From: Karl Mclaughlin
Sent: 25 January 2019 10:51
To: Planning.Responses
Subject: Planning Consultation on: M/153/18/PL

**1 No. dwelling with detached garage (amendment following M/7/16/PL)
(M/153/18/PL)**

**Land adjacent to 46 Sea Lane, Middleton-On-Sea
PO22 7RX**

South Elevation 1:100 @A3

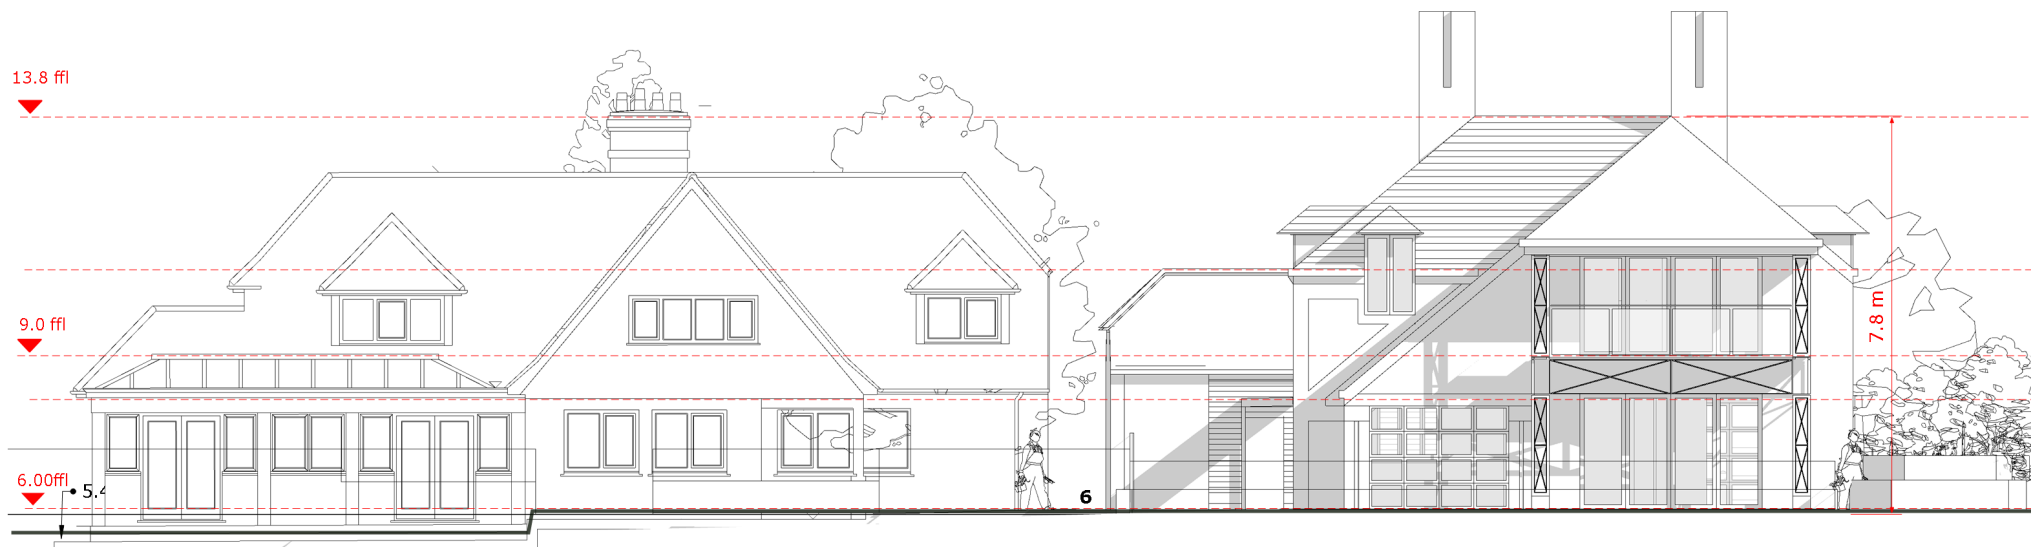
Due to the proximity of the site to the sea and the local authority's intimate knowledge of the area it would be prudent to reconsider the glass finishes to the rear (seaward) of the property. More specifically the glass balustrade and shade. Equally, of similar concern, some of the drawings show a glass box atop the building. It has been known that during periods of severe weather wave energy reflected by the seawall has carried sand, gravel and shingle over seafront properties. To this end I am unsure as to how the box would perform in such conditions and felt that the applicant should be made aware of the risks.
